**CITY OF PORTLAND, MAINE
DEVELOPMENT REVIEW APPLICATION
PLANNING DEPARTMENT PROCESSING FORM
DRC Copy**

2005-0208
Application I. D. Number
8/30/2005
Application Date
Single Family Home Lot#9
Project Name/Description

56 - 56 Ruby Ln, Portland, Maine
Address of Proposed Site
342 B027001
Assessor's Reference: Chart-Block-Lot

The following are my review comments pertaining to the site plan for lot #7, Ruby Lane:

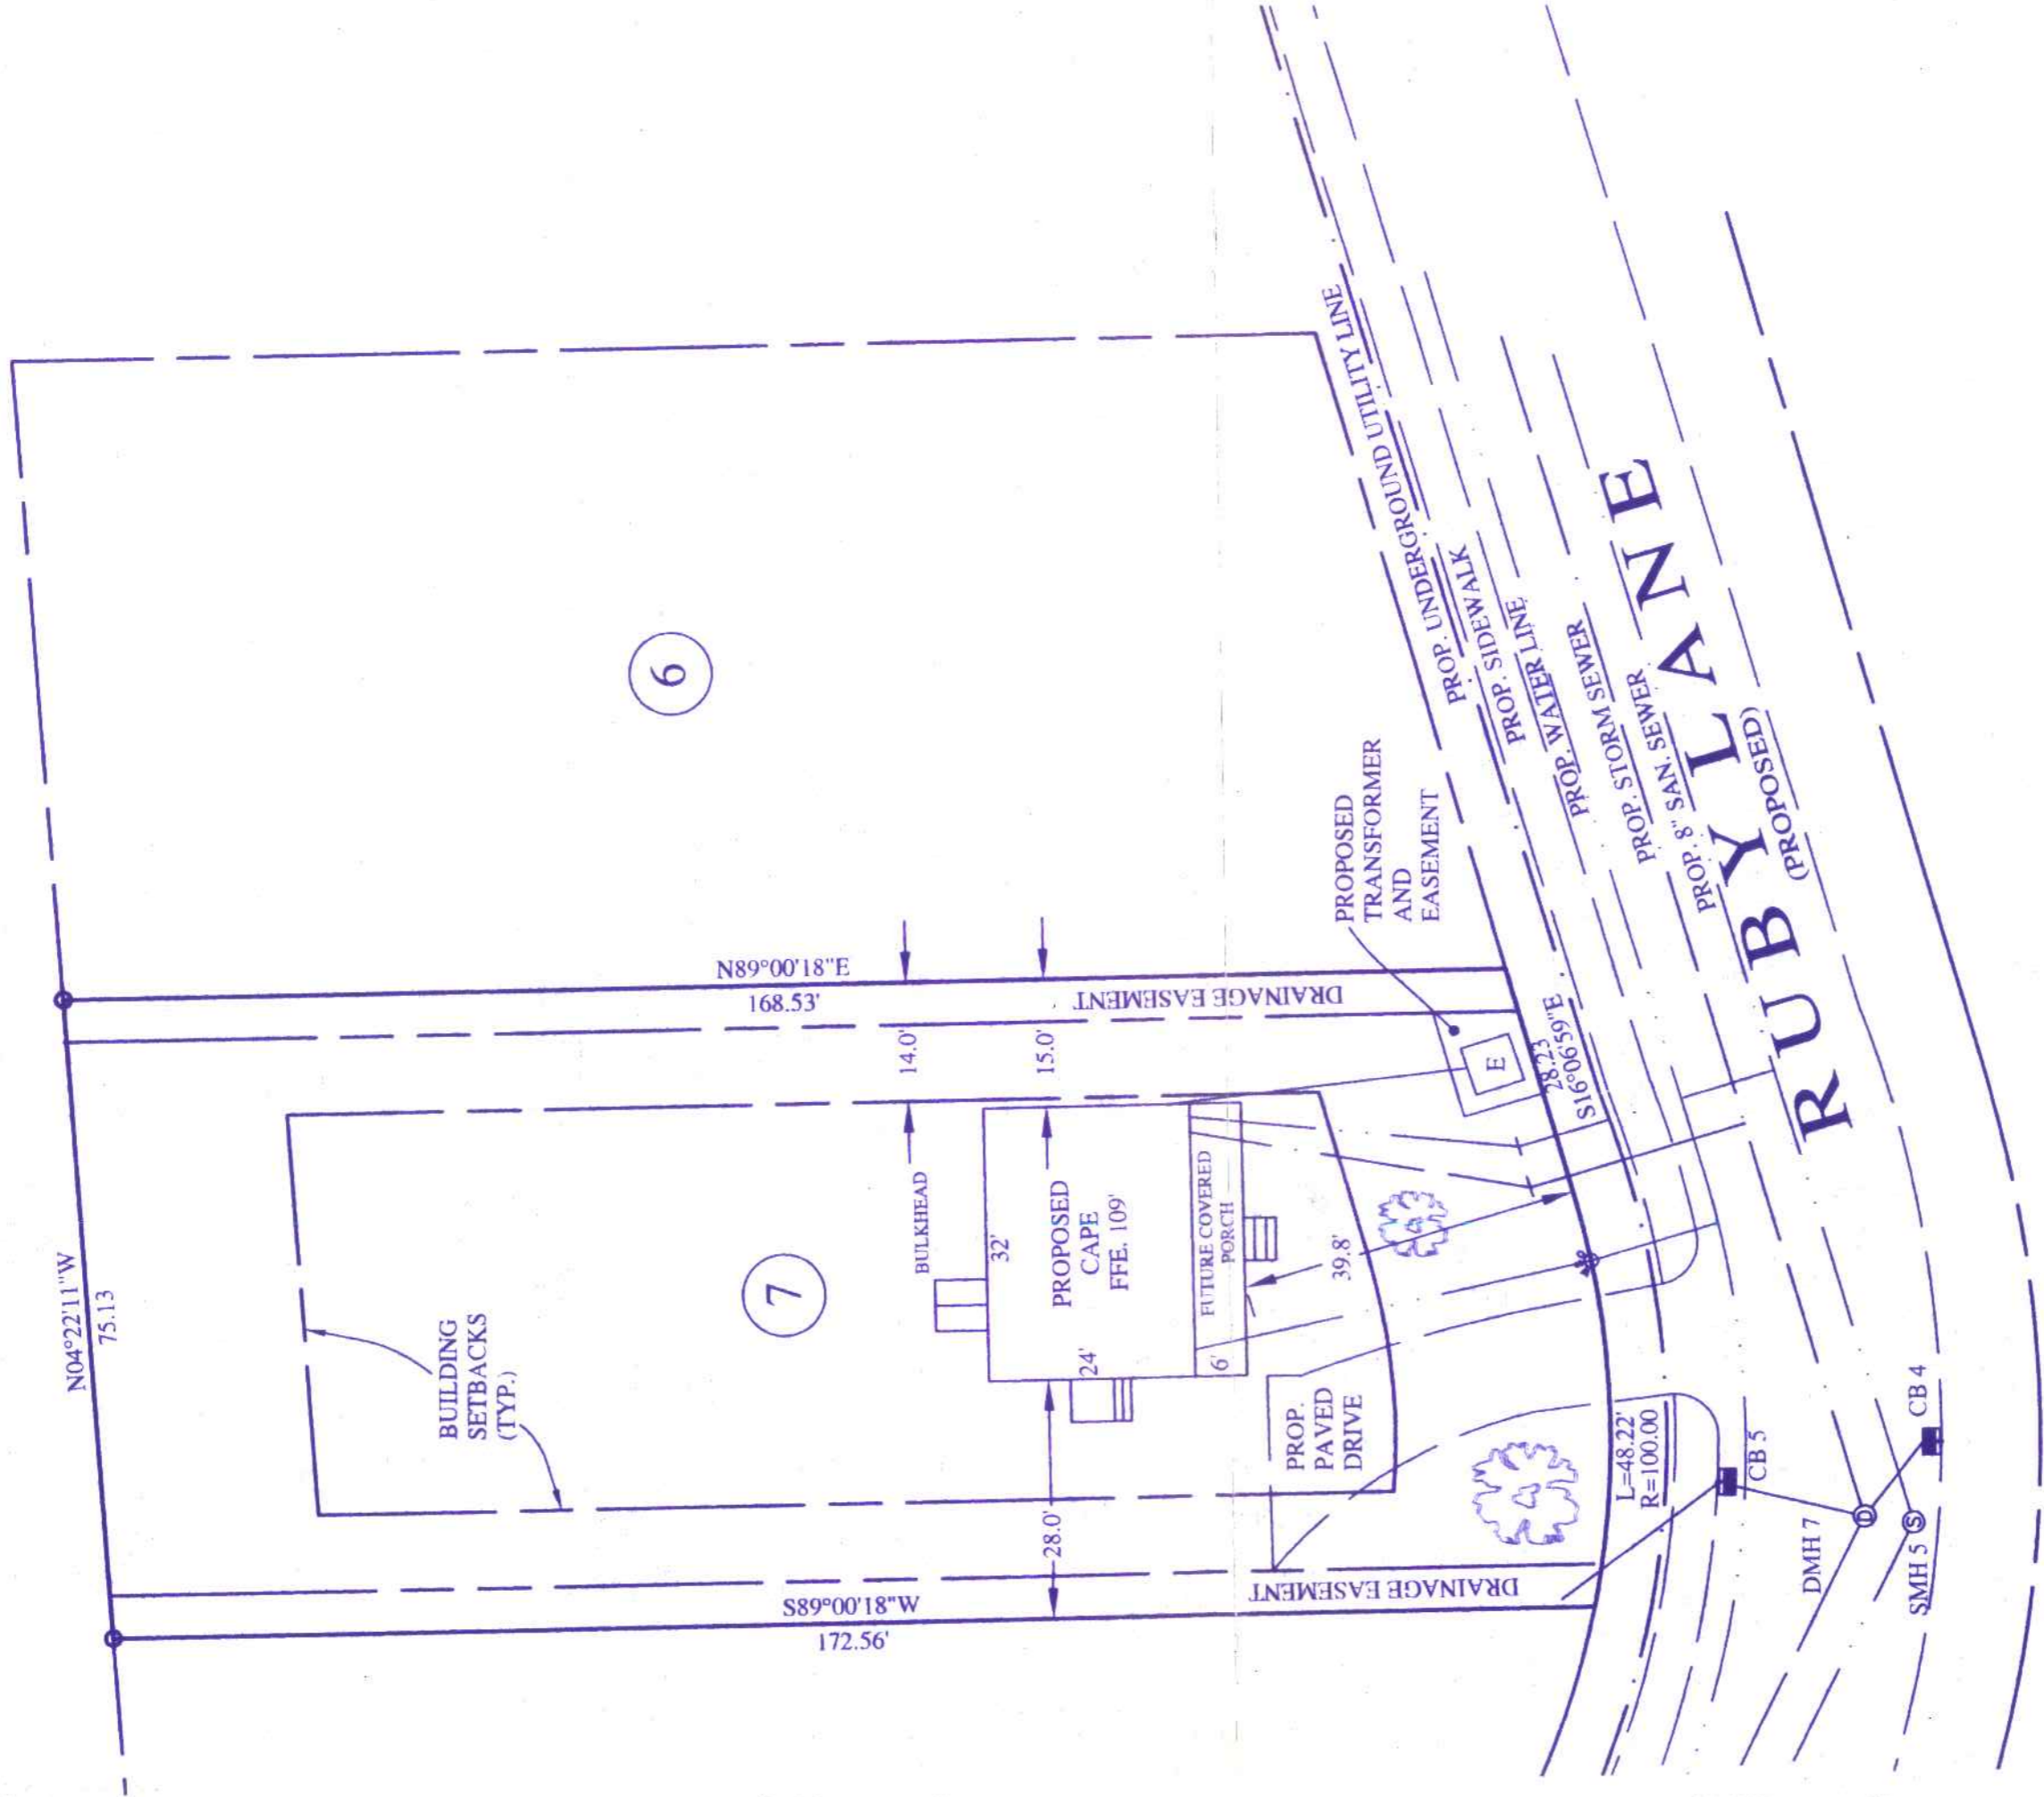
1. Your site plan needs to show two, 9'x19' parking spaces beyond the front setback.
2. Your site plan needs to show existing and proposed topography.
3. Please add erosion control/silt fence to the plan.
4. Your site plan needs to show the existing trees on lot #7 that are flagged to be preserved.
5. Your site plan needs to show the 25-foot no-cut zone in the rear of the property.
